DECISION DELEGATED TO DEVELOPMENT MANAGER

Application No: H16-0960-17 **Applicant:** Delicija
Proposal: Replacement ramp access and associated works
Location: Unit 2, 20 Westlode Street Spalding Lincs
Terminal Date: 5th February 2018

Proposed Balustrade

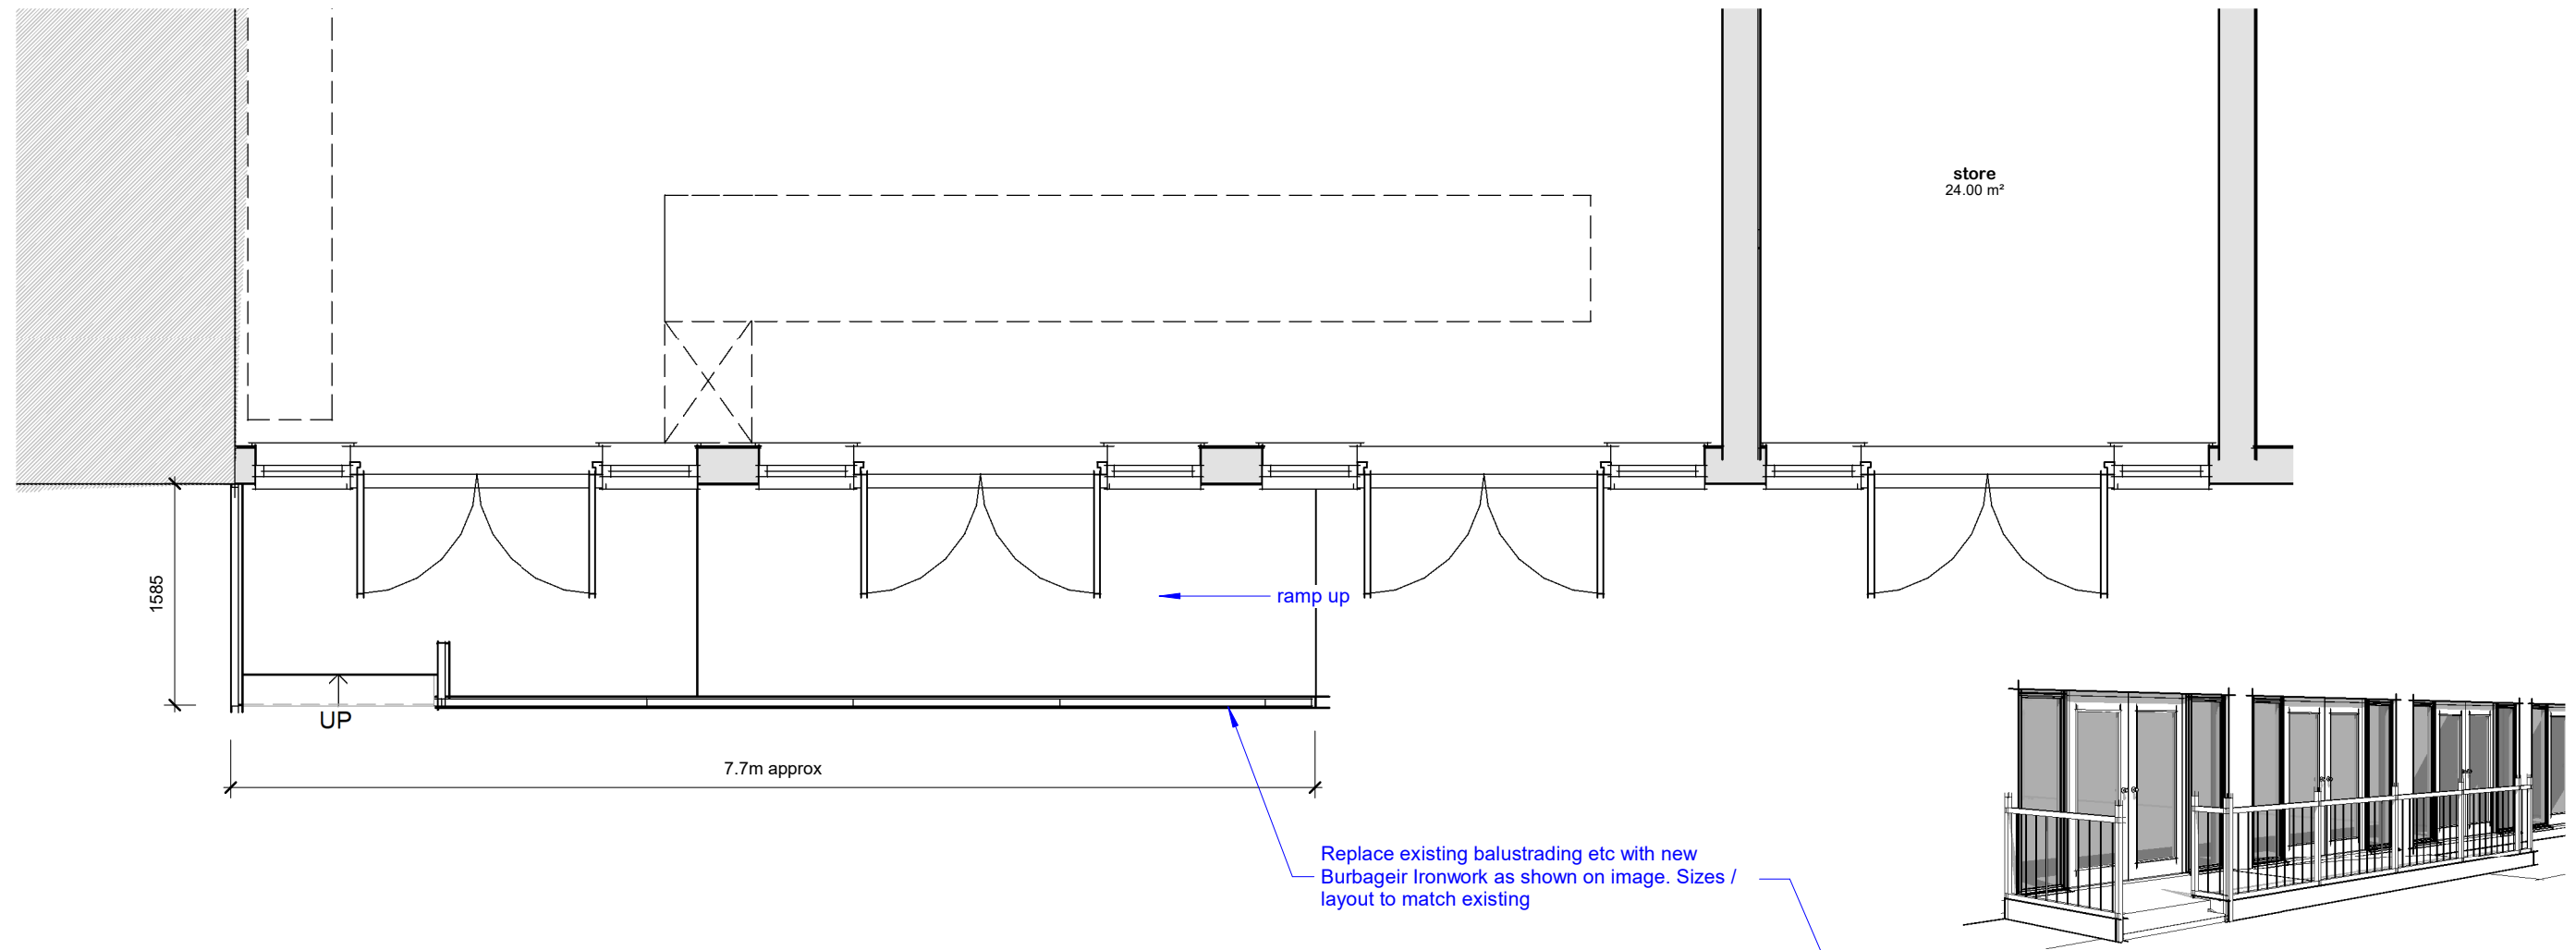
"Having looked into the case I consider that black metal railings to the ramped/raised section would be far smarter and would work better in preserving/enhancing the Conservation Area than timber which would look out of place and deteriorate over the years." The plans have been subsequently amended to address this.
